Item No. **Report of the Interim Director of Planning, Regeneration & Public Realm**

Address 236 WOODLANDS AVENUE RUISLIP

Development: Retention of hip to gable loft and single storey rear extension as constructed, rear dormer and front porch.

LBH Ref Nos: **9248/APP/2022/2237**

JOB TITLE		28 WOODLANDS AVENUE	
EASTOOTE		H44 BOX	
DRAWING TITLE		AS BUILT ELEVATIONS	
DATE	SCALE	DATE	SCALE
JULY 2022	1:100.	JULY 2022	1:100.
DRAWING No.	P	06

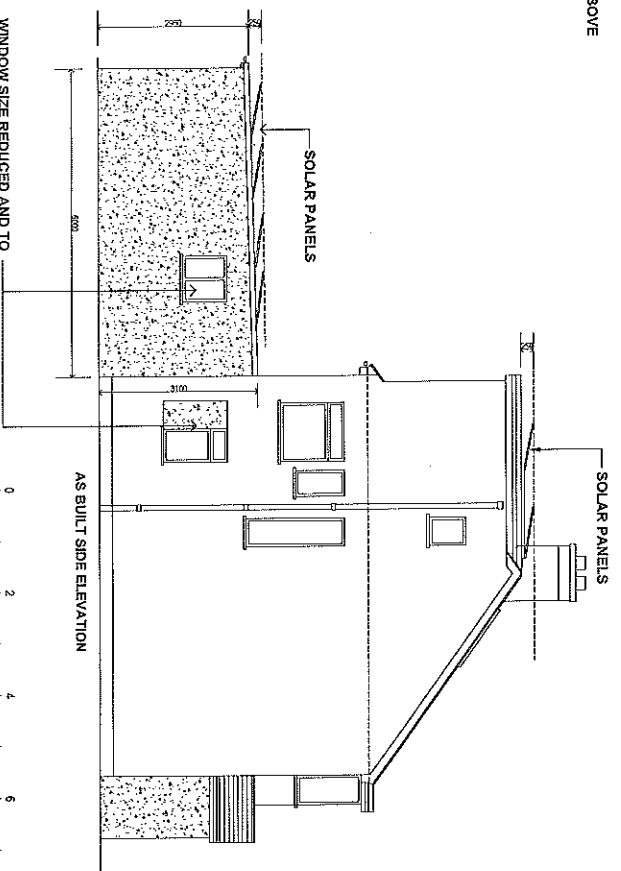
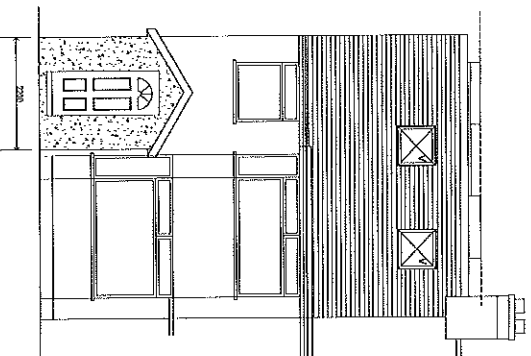
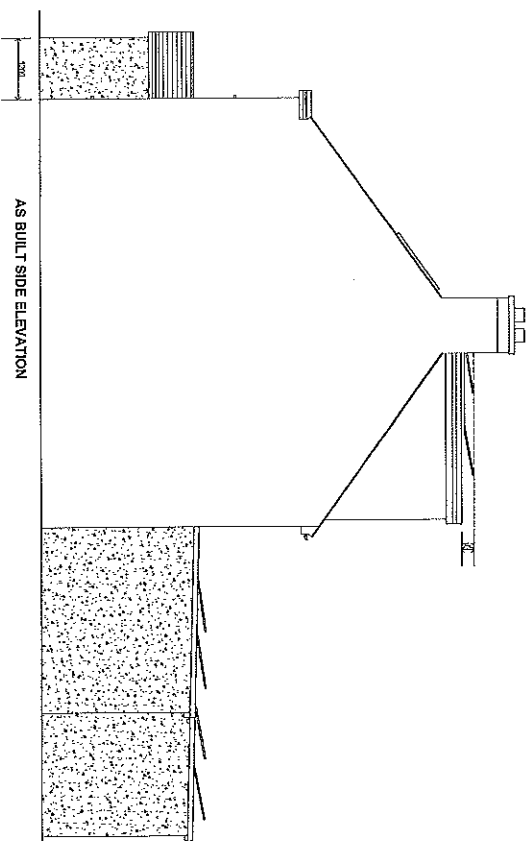
The 'as built' drawings show the height of the single storey rear extension has been increased by 10cm; it also shows a new front porch with a pitched roof. The drawings also show the installation of solar panels on the flat roof of the single storey rear extension and

on the flat roof of the rear dormer with the solar panels projecting 25cm above the main ridge. The drawings also show the flat roof of the rear dormer is flush with the main ridge not set down below it. Whilst the drawings show the ridge height as being the same as the adjoining neighbour, it would appear the roof height has in fact been increased.

The roof form of the dwelling has been altered from a hipped roof to a gabled end on the west/ side elevation. Two rooflights have been inserted in the front roofslope. With only a 20cm gap to the side elevation and the shared boundary with the adjoining neighbour, the roof ridge not being set down from the main roof ridge, the overly large dormer dominates the rear roofslope and results in an incongruous addition to the streetscene. The width of the rear dormer would exceed more than two thirds the average width of the original roof and would not be considered subservient, contrary to criteria i) of Policy DMHD 1.

The visual prominence of the roof alterations/extension including the raising of the roof ridge is further worsened by the poor choice of exterior materials, the projecting solar panels and the altering of the roof form of the dwelling by converting its hipped roof profile to an uncharacteristic part gable on one side. The proposal would fail to accord with Policy DMHD 1 which is clear that new extensions should respect the design of the original house and be of matching materials and that poorly designed or overlarge roof extensions including proposals to convert an existing hipped roof to a gable would not be supported.

DRAWING No.
P 04

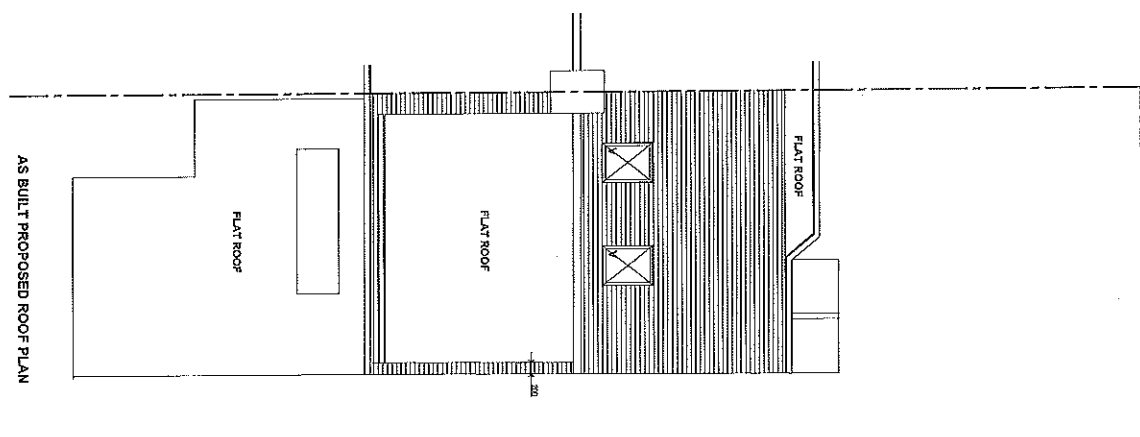
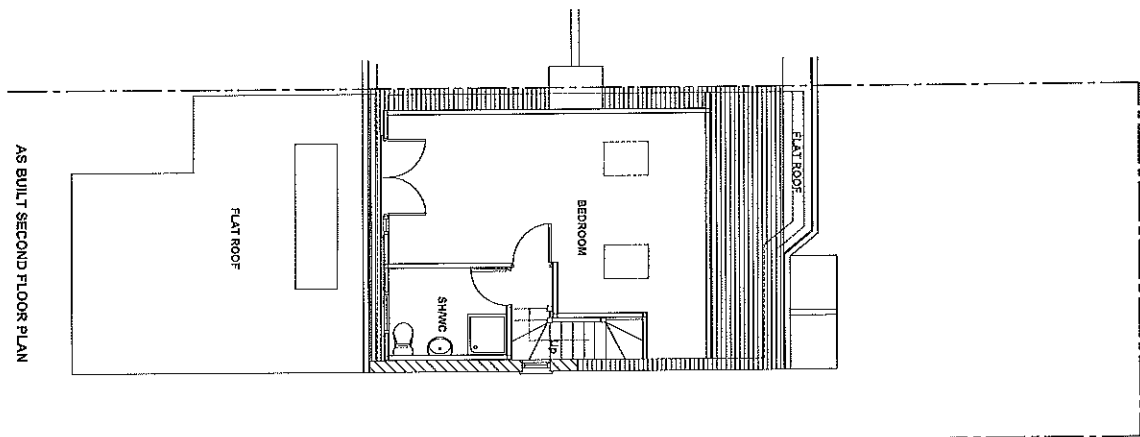
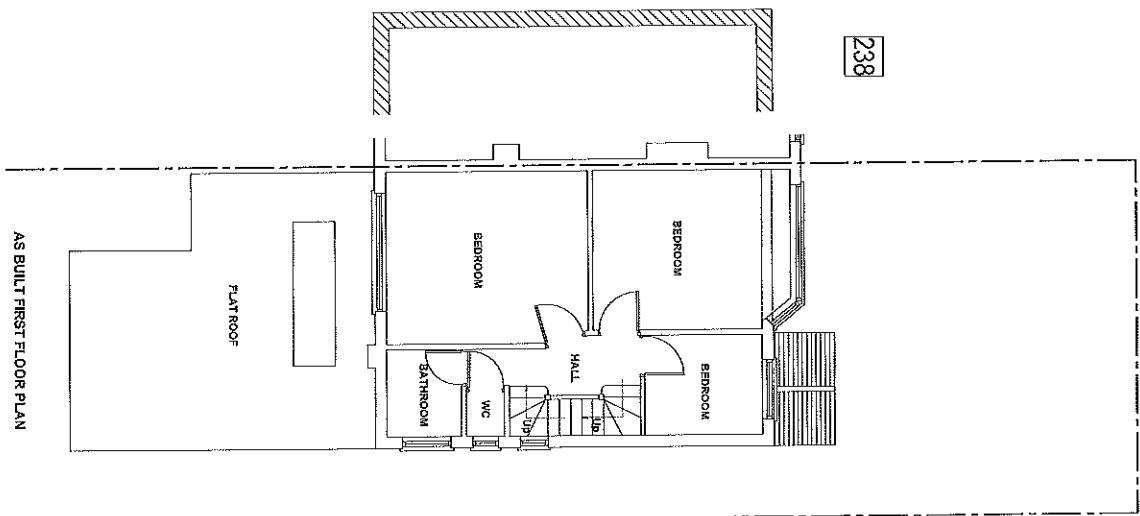
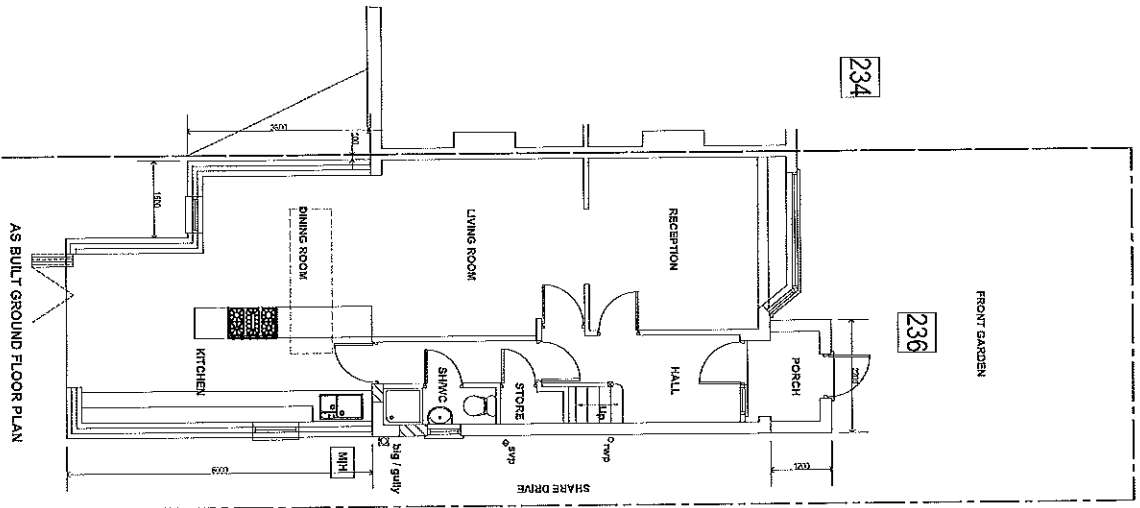
From the application form, the works have commenced on 16/08/2021, however have not been completed. It is noted the 'approved' elevation drawings now contain annotations relating to the roof alterations and the volume calculation of the rear dormer. There is a text box noting the loft constructed under permitted development. Another text box notes exterior materials shall match the existing dwelling. The 'approved' drawing now also features a front elevation showing the hip to gable adjustment, which wasn't previously shown.
